Submission No.			283	
Organisation Name or Name of Submitter			Smyths Toys Superstores (represented by RW Nowlan & Associates)	
Item No.	Section Ref.	Page No.	Observation Statement	TII Response
Submission on Proposed Railway (Metrolink - Estuary to Charlemont Via Dublin Airport) Order (2022)				
1	Executive summary	1	Under the proposed Railway Order the existing store would need to be demolished. The implications of the loss of this store to the area would be significant given the expected population growth in the area.	Where Smyths Toys Superstores occupational interest at Airside Retail Park is to be acquired by the use of compulsory purchase powers then they would be entitled make a claim for compensation in accordance with the compensation code. The Code provides that qualifying occupiers can recover the reasonable costs of relocation which have been properly and necessarily incurred as a direct consequence of the acquisition.

NOTES:

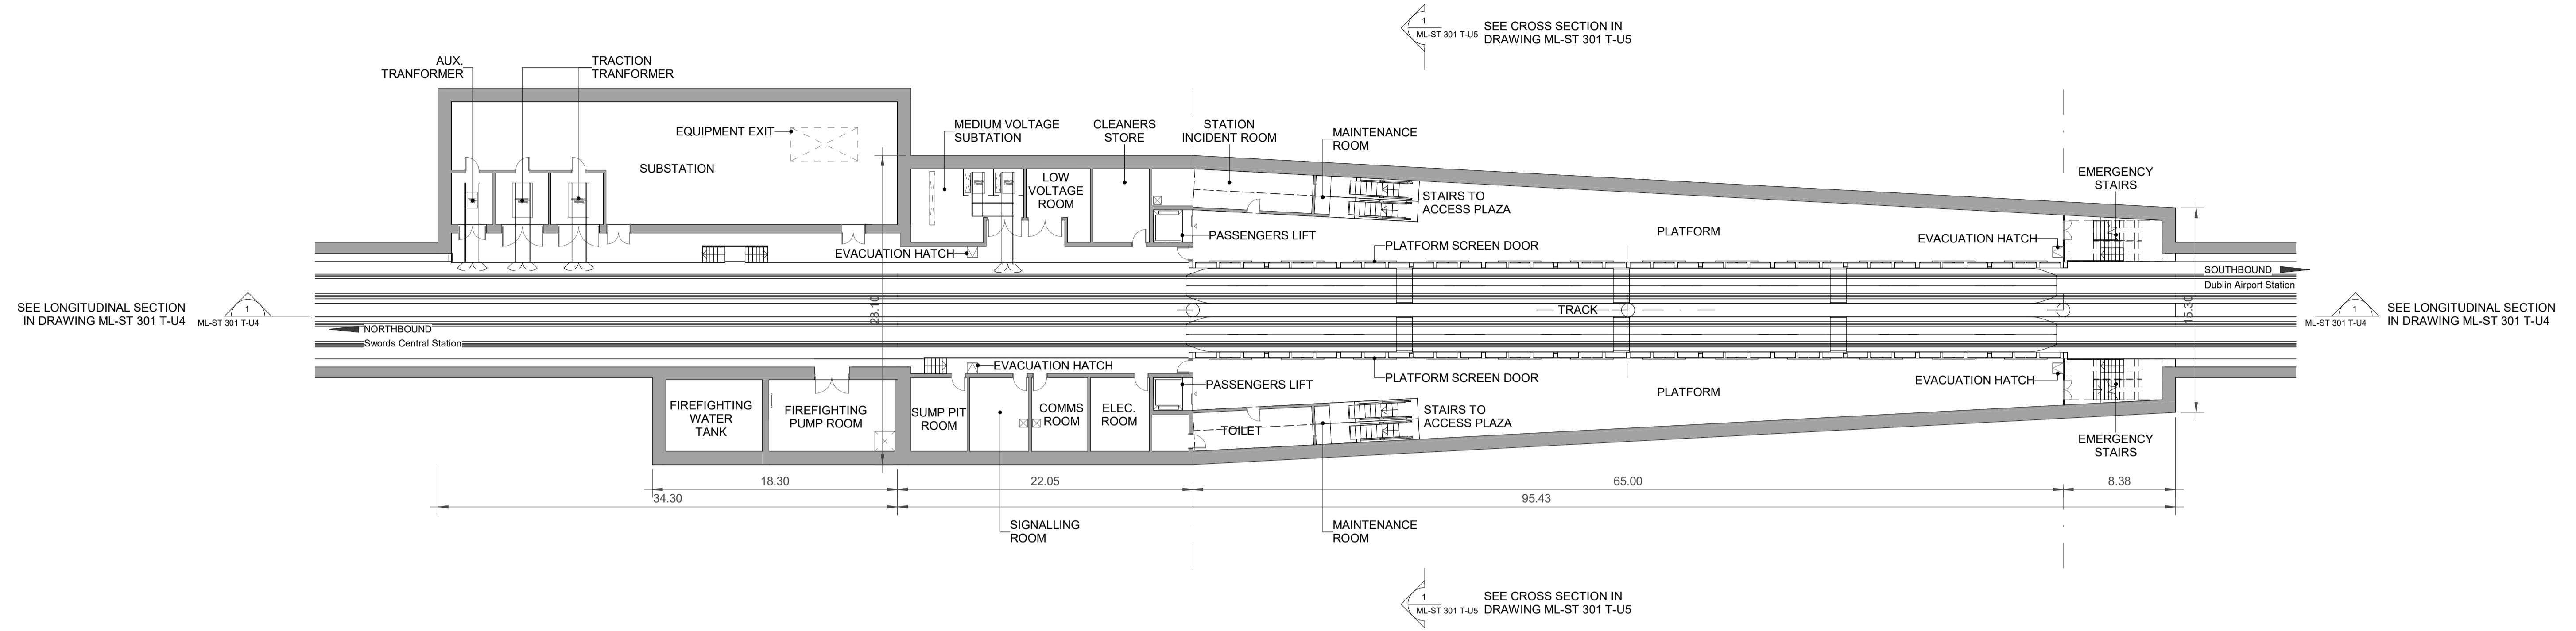
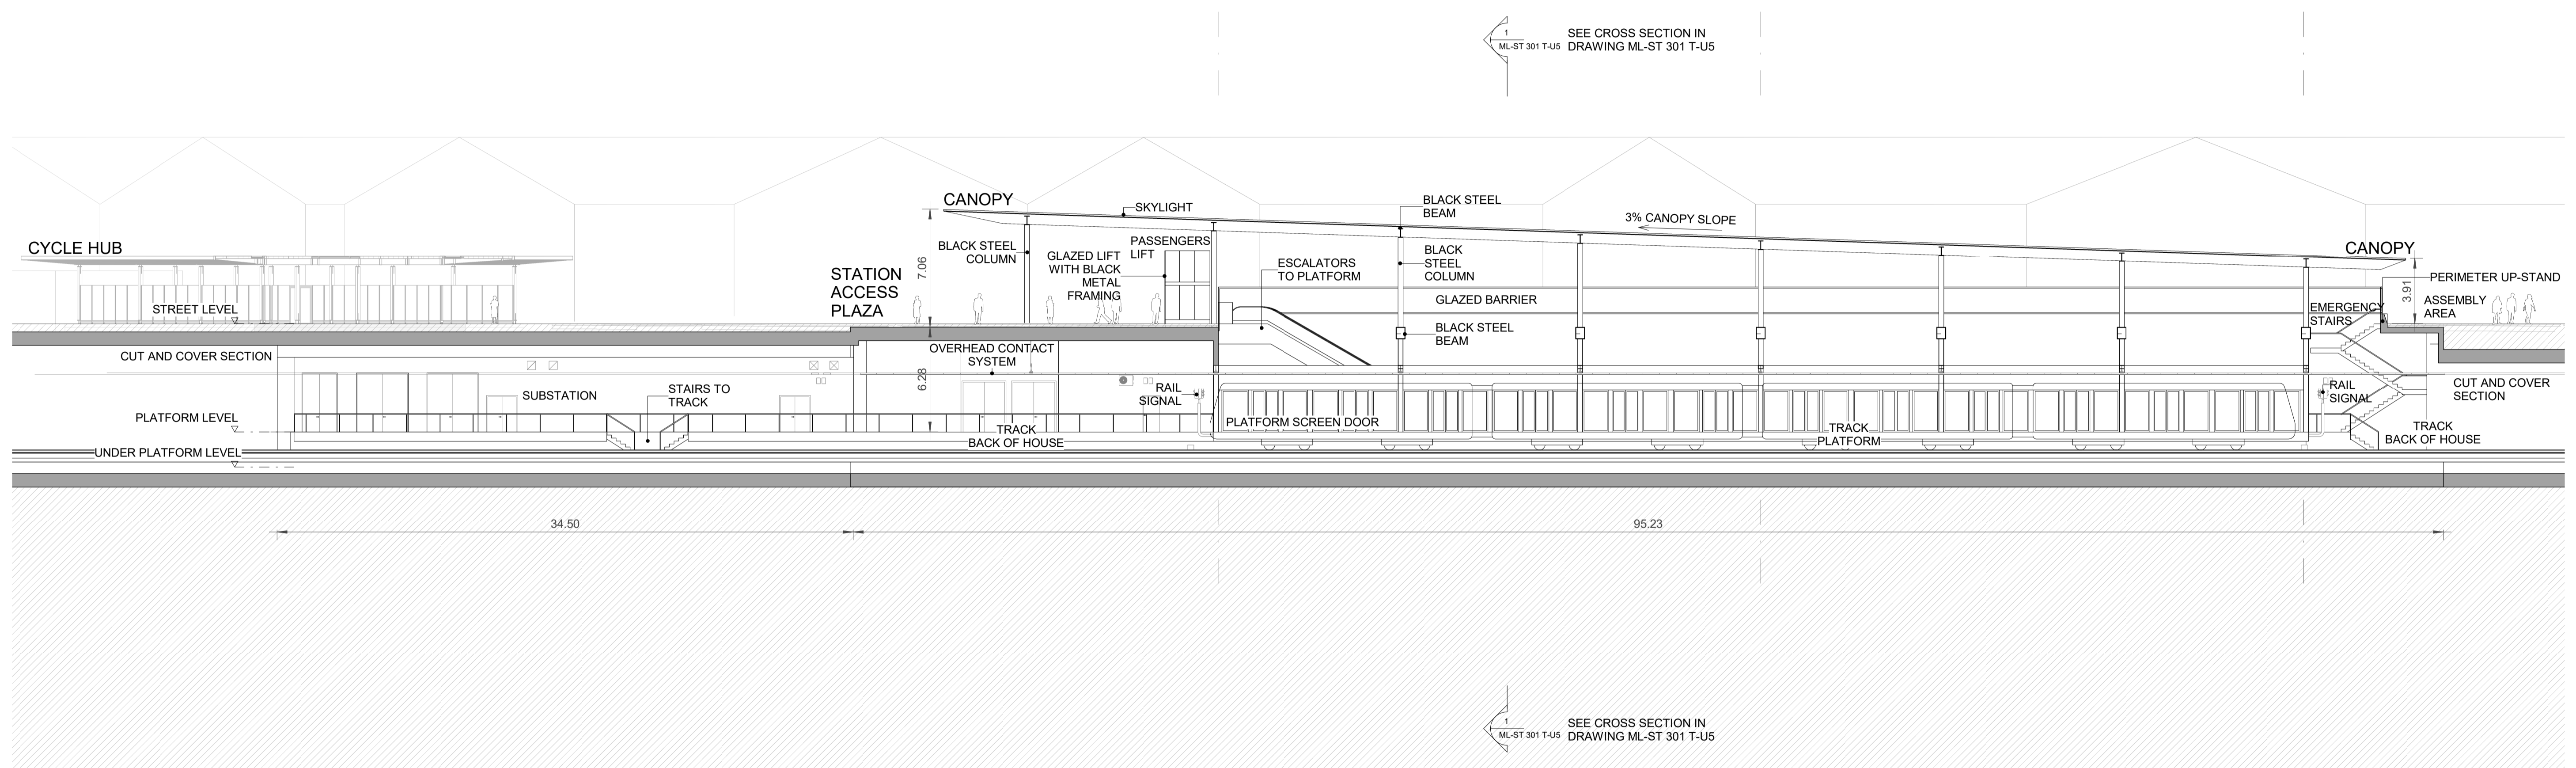
6	6.0 Fosterstown Station Materially Contravenes the Development Plan	5	6.2 The zoning objective in the draft development plan (which will soon become the operative plan) is Retail Warehousing and the objective is: ... <i>"To Provide for Retail Warehousing."</i> The zoning objective for Retail Warehousing does not facilitate the proposed use of a metro railway station. The planning report states the following in this regard: ... <i>"Fosterstown Station lies within lands zoned as HT and RW in the Fingal FDP. Under these zoning objectives, 'public transport station' does not come within either 'Permitted in Principle' or 'Not Permitted' uses. The FDP notes that 'Uses which are neither 'Permitted in Principle' nor 'Not Permitted' will be assessed in terms of their contribution towards the achievement of the Zoning Objective and Vision and their compliance and consistency with the policies and objectives of the Development Plan."</i>  6.3 It is difficult to see how the proposed metro station would contribute towards the objective to provide for retail warehousing. In fact, it does exactly the opposite: it would remove a large retail warehouse building from the retail warehouse park without suggesting an alternative location for this building.  6.4 The proposed development therefore materially contravenes the development plan zoning objective.	As per the Planning Report, Fosterstown Station lies within lands zoned as HT and RW in the Fingal FCDP. Under these zoning objectives, 'public transport station' does not come within either 'Permitted in Principle' or 'Not Permitted' uses. However, the FDP notes that 'Uses which are neither 'Permitted in Principle' nor 'Not Permitted' will be assessed in terms of their contribution towards the achievement of the Zoning Objective and Vision and their compliance and consistency with the policies and objectives of the Development Plan.  Therefore, in consideration of the fact that the proposed project is of strategic importance to the long-term development of the Dublin region for land-use and transport and has been specifically identified as being of national importance in the National Planning Framework, National Development Plan, Fingal Development Plan and other key statutory documents, it is considered that the proposed station is consistent with the strategic policies and objectives of the development plan, and therefore TII do not agree with the observation statement that "The proposed development therefore materially contravenes the development plan zoning objective".

10	9.0 Conclusions bullet 1	8	The proposed demolition of the existing retail store to facilitate the development of a railway station would materially contravene a zoning objective in the current and draft county development plans.	Please refer to response (3) above.
11	9.0 Conclusions bullet 2	9	The proposed railway station is in a different location to that shown in the development plan for the area. The justification for this change in location is not provided in the application for the Railway Order.	Please refer to response (7) above.
12	9.0 Conclusions bullet 3	9	No provision is made in the proposed Railway Order for a replacement or relocation of the existing retail store even though the demolition of the existing store is stated to be necessary	Please refer to response (8) above.
13	9.0 Conclusions bullet 4	9	While the planning report refers to 'capacity" to construct a new unit to replace the demolished unit nothing has been proposed and it is unclear where the capacity exists.	Please refer to response (8) above.
